The Design Review Panel

Site	Oxpens Wigginton, Banbury, Oxfordshire, OX15 4JZ
Proposal	Proposed Para 79 House
Local Authority	Cherwell District Council
Applicant	Virginia Sweetingham
Agent	Hughes Planning
Architect	Seymour-Smith Architects
Landscape Architect	Seed Landscape Design
Review Date	22 nd April 2020

This remote desktop review was booked by Virginia Sweetingham, and this is the third time The Design Review Panel has reviewed this scheme. Previous sessions have been held on 15th November 2019, (including a site visit), and 13th February 2020, and this remote desktop review is provided having regard to the previous reviews and written feedback documents.

Oxpens, Wigginton
Stone Barn in NW of Damp Meadow
Plans and Elevations as Existing

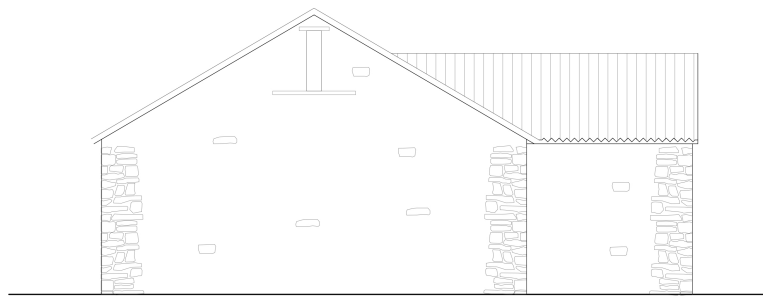
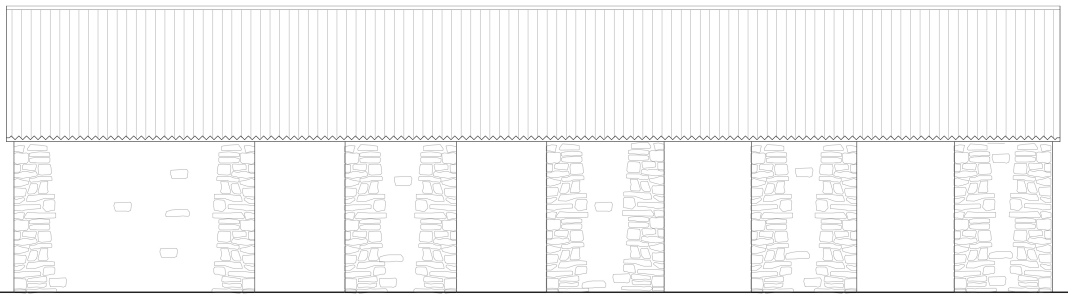
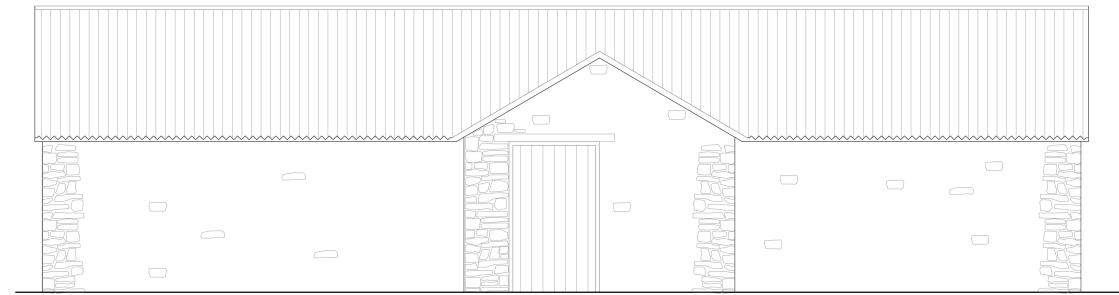
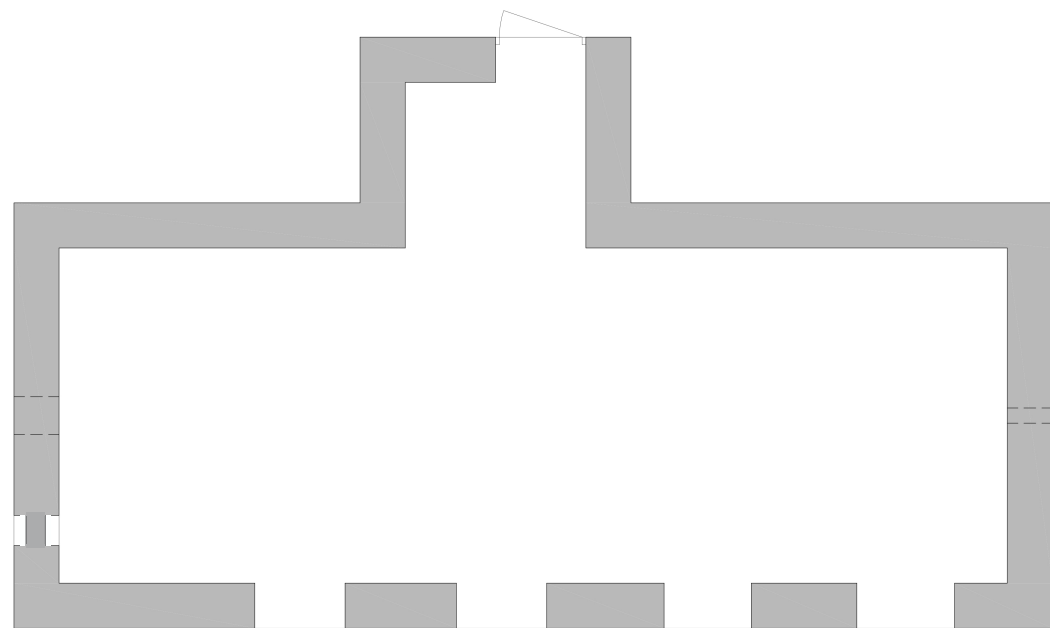
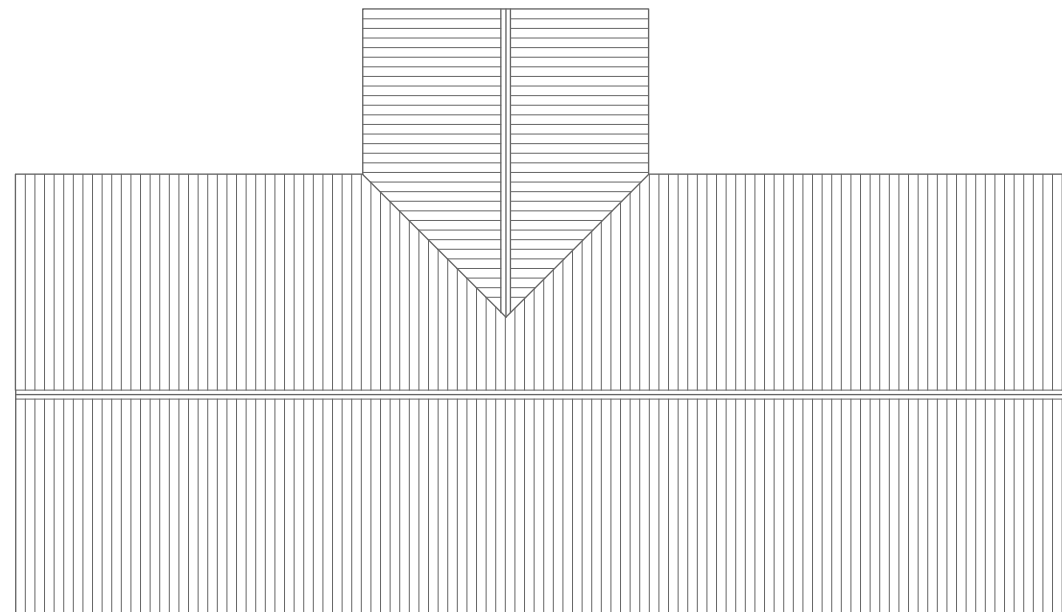
It is felt that the proposed concrete footprint, by the Old Barn, may benefit from being the same material as the track; there is a concern the proposed concrete may appear out of character.
